CITY OF ALBUQUERQUE

August 10, 2022

Re: Duplex for Ahmet Tiryaki
12016 Copper Ave NE
Traffic Circulation Layout
Architect's Stamp 07-07-2022 (K22-D065)

12,016 COPPER AVE. N.E.
ALBUQUERQUE, NEW MEXICO
STOPPING SIGHT
DISTANCE PLAN

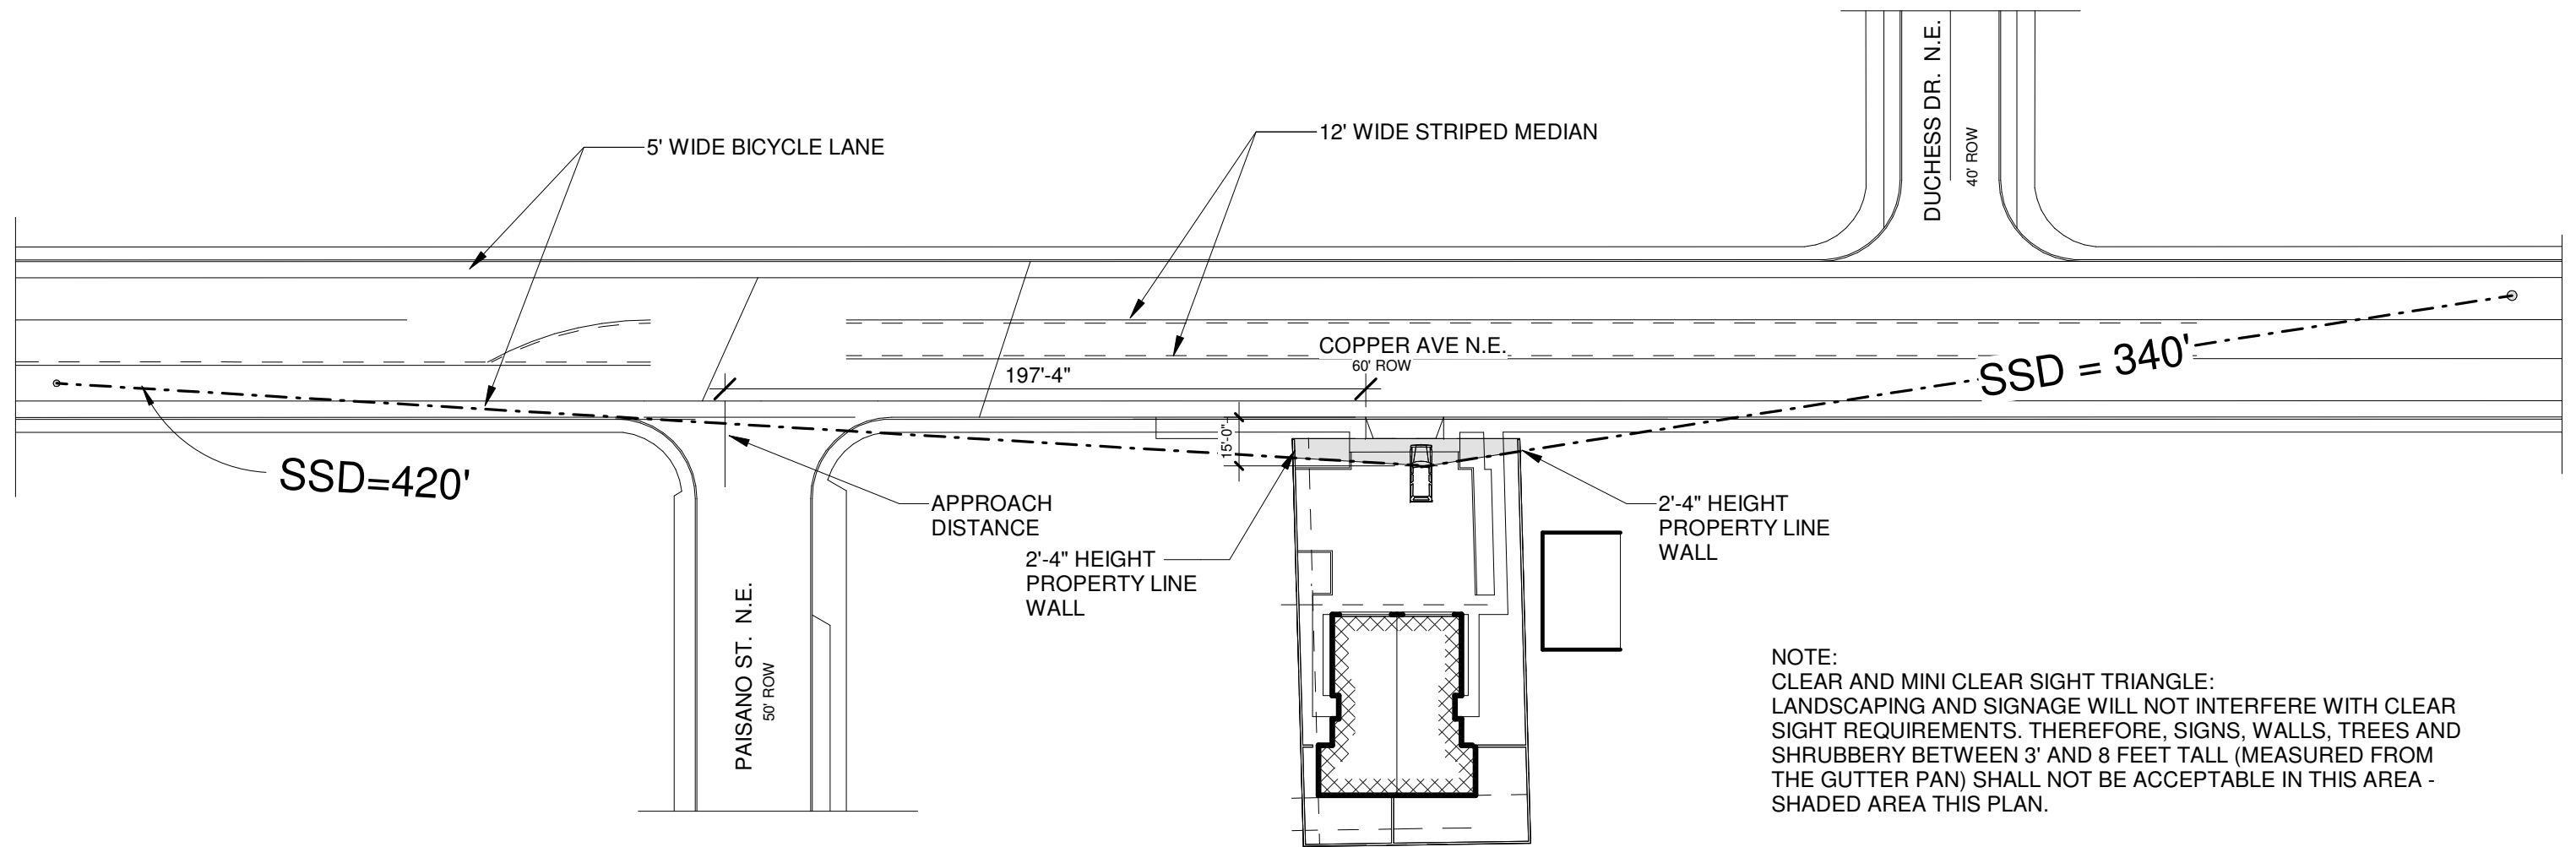
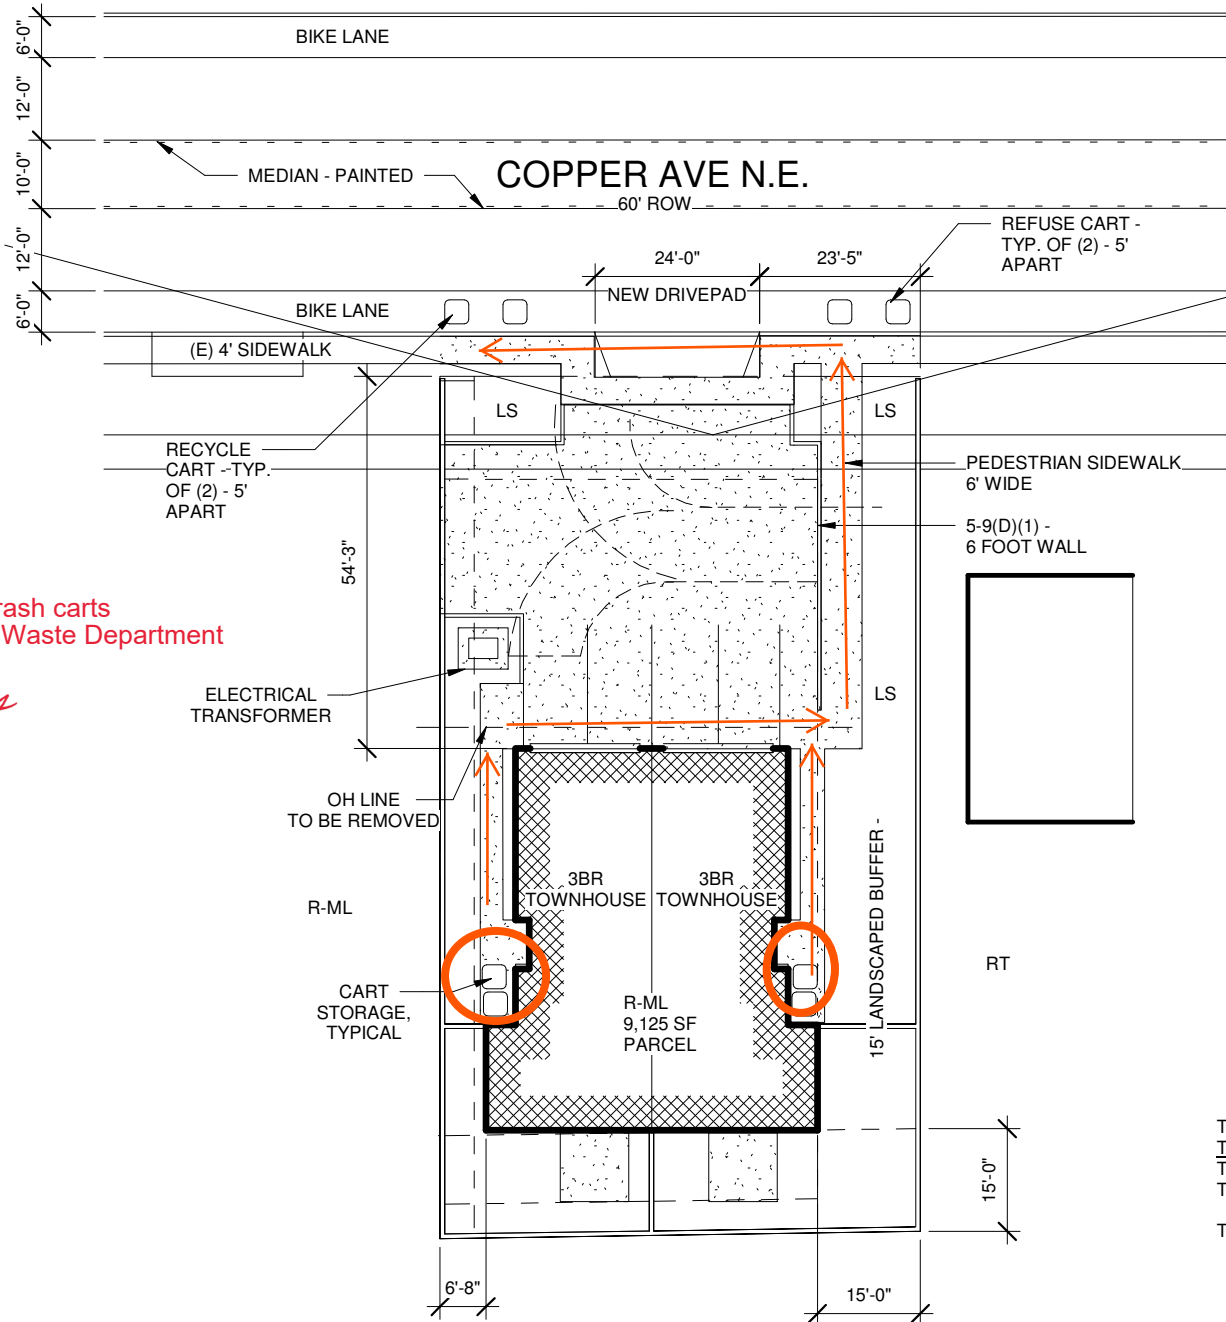
8. Fire Department: An approval Fire 1 plan needs to be provided.
9. **Sight distance:**
 - Is stopping distance line blocked by proposed wall? Or is it 6 inch curbing within this segment of property boundary.
 - The provided a clear sight triangle (11'x11') will need to be located behind sidewalk/pathway.
10. Please provide a letter of response for all comments given.
